WEST SUSSEX COUNTY COUNCIL CONSULTATION

TO:	<u>Arun</u> District Council <u>FAO:</u> Raymond Cole
FROM:	Stephen Gee <u>WSCC</u> - Highways Authority
DATE:	18 March 2021
LOCATION:	Land To East Of <u>Fontwell</u> Racecourse <u>Fontwell</u> Avenue <u>Eastergate</u> <u>BN18 0SW</u>
SUBJECT:	WA/100/20/DOC Approval of details <u>reserved</u> by condition imposed under APP/C3810/V/16/3143095 (WA/22/15/OUT) relating to Condition Nos 9 - Public Open Spaces, 10 - hard & soft Landscaping, 11 - protection of retained trees, 19 - Construction Management Plan, 22 - decentralised & renewable energy, 25 - Travel Plan and 26 - Non-Motorised User Audit. Amendment received.
DATE OF SITE VISIT:	<u>n/a</u>
RECOMMENDATION:	No Objection / More Information
S106 CONTRIBUTION TOTAL:	<u>n/a.</u>

19 - Construction Management Plan - Further Information required

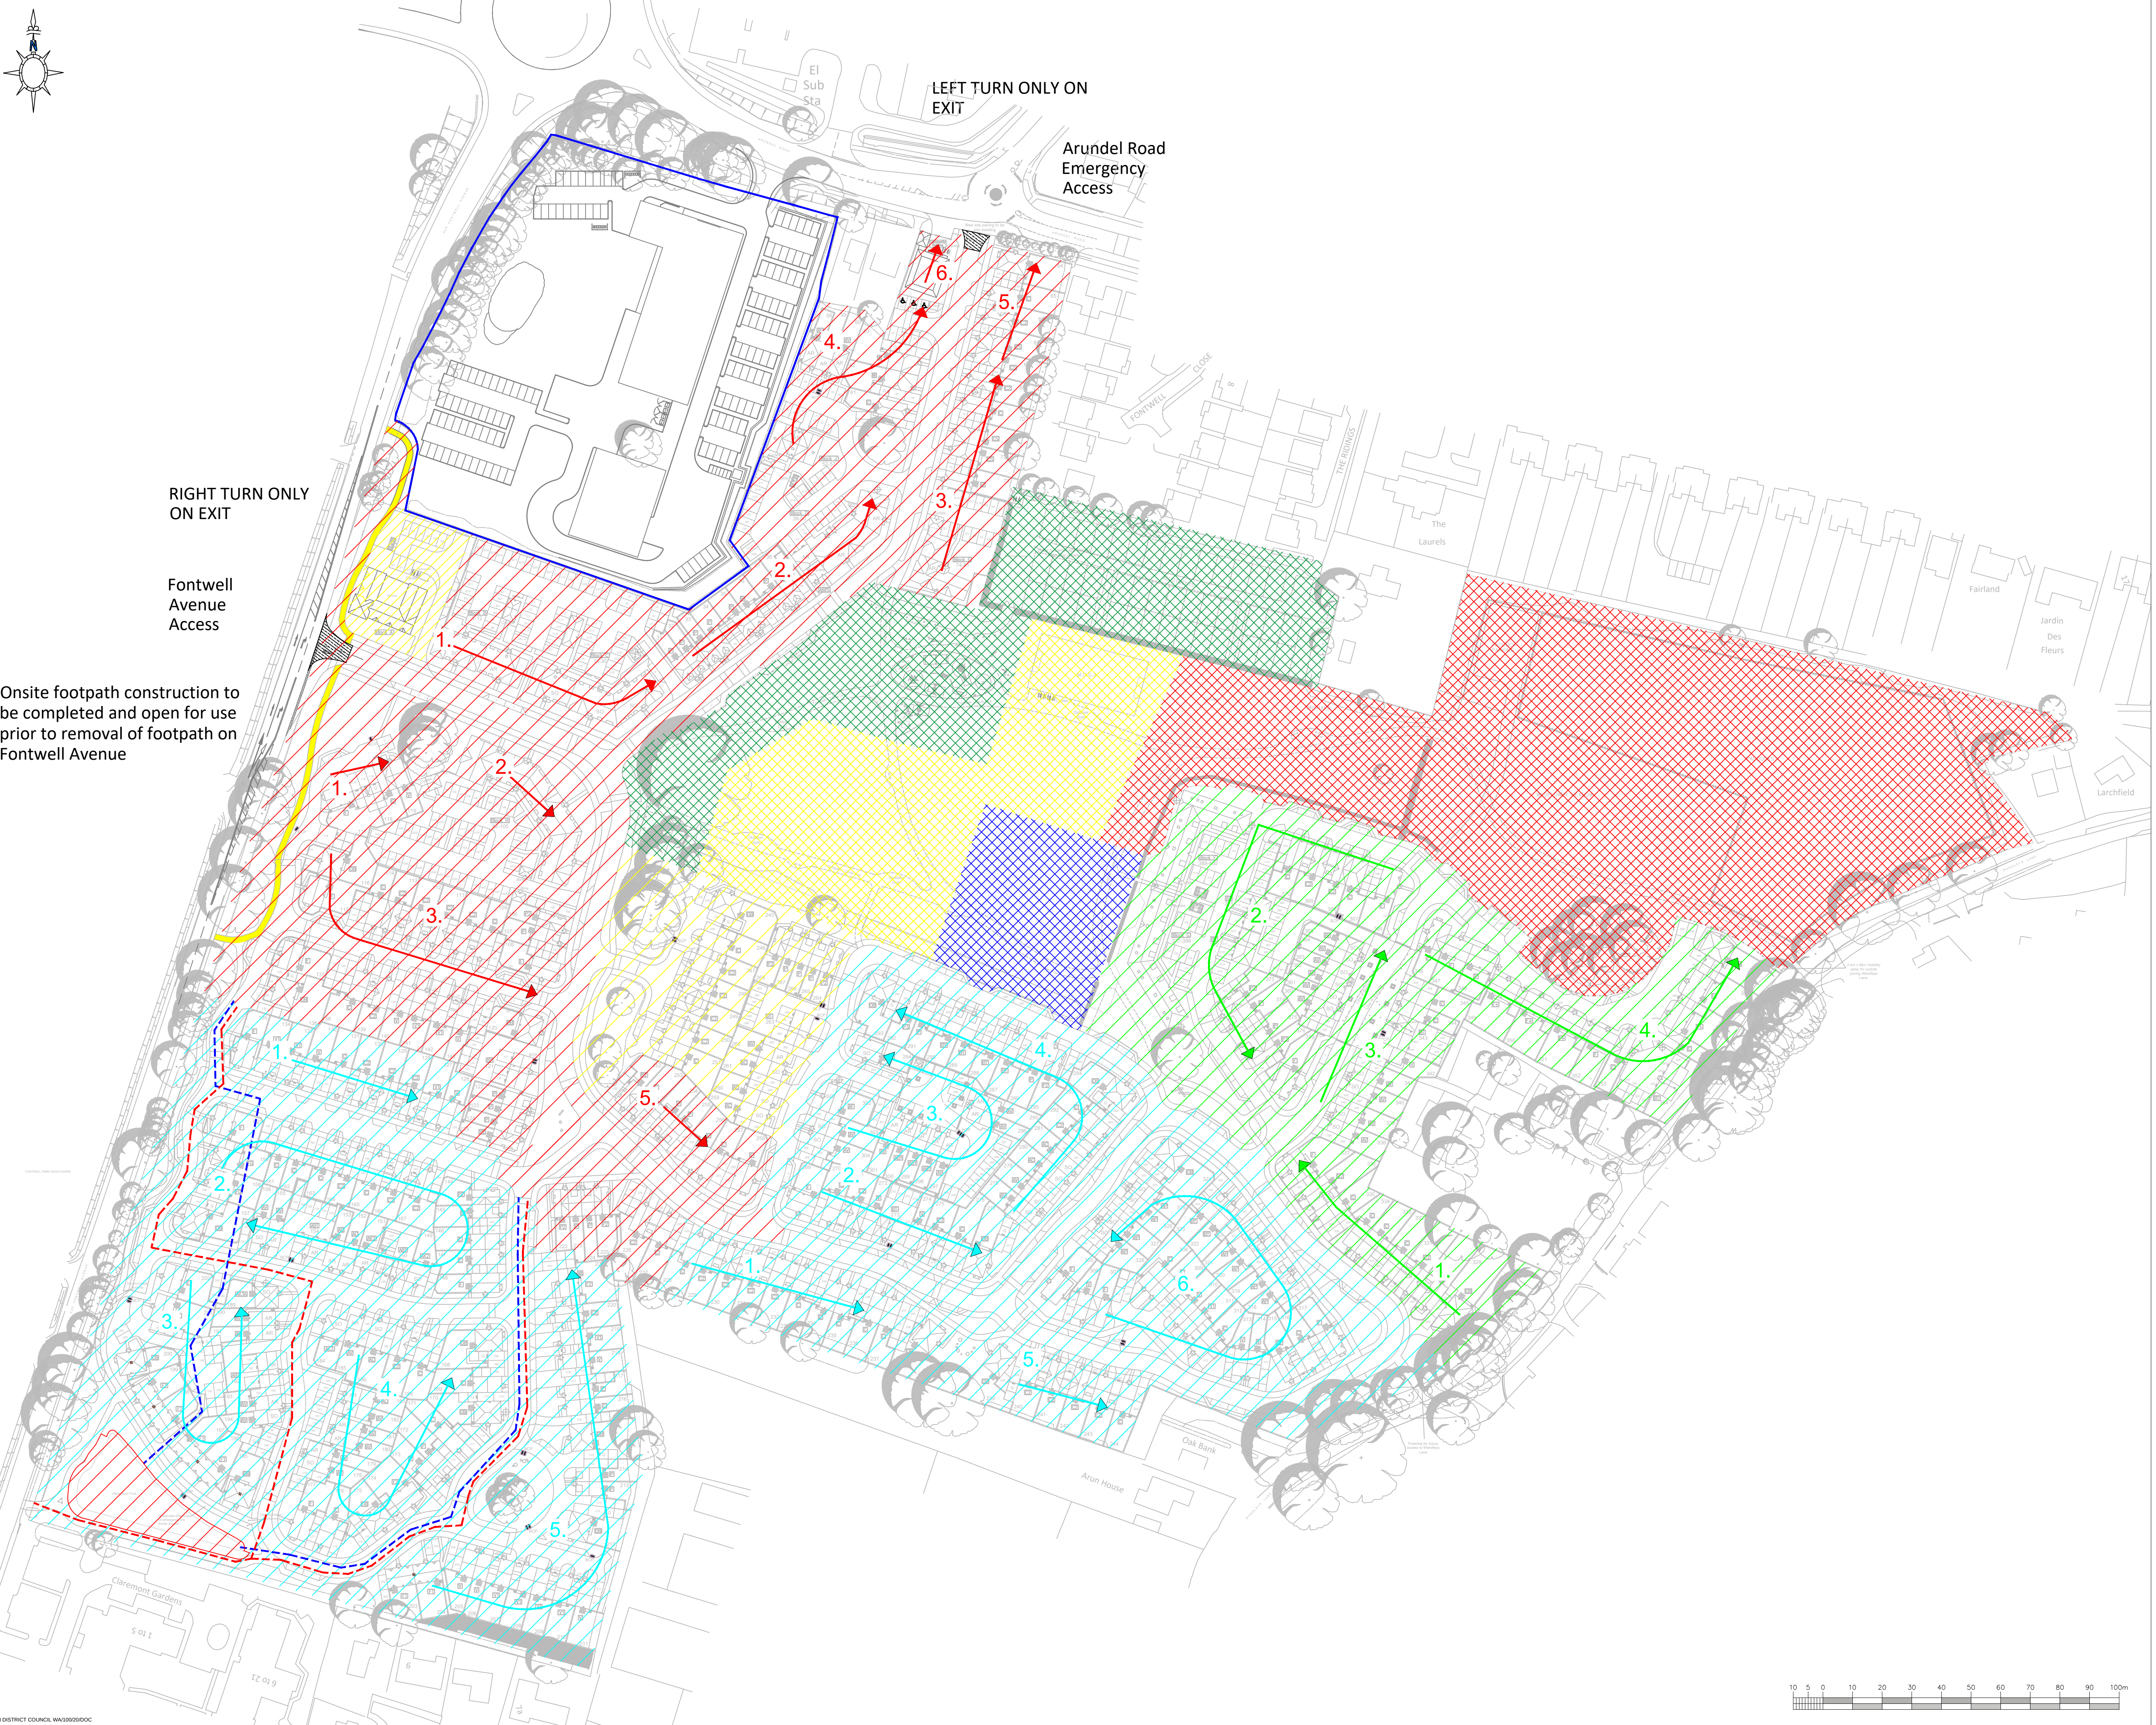
"The access onto Fontwell Avenue will be completed prior to 103rd occupation as per the S106 Agreement, at which point the junction onto Arundel Road will be restricted for use as emergency access only. Until completion of the access onto Fontwell Avenue, it will be appropriate to utilise both points of access in order to complete the phased construction and infrastructure works and mitigate impact on the neighbours whilst limiting traffic on the existing highways."

The applicant should identify what measures would restrict general traffic utilising the route through the development.
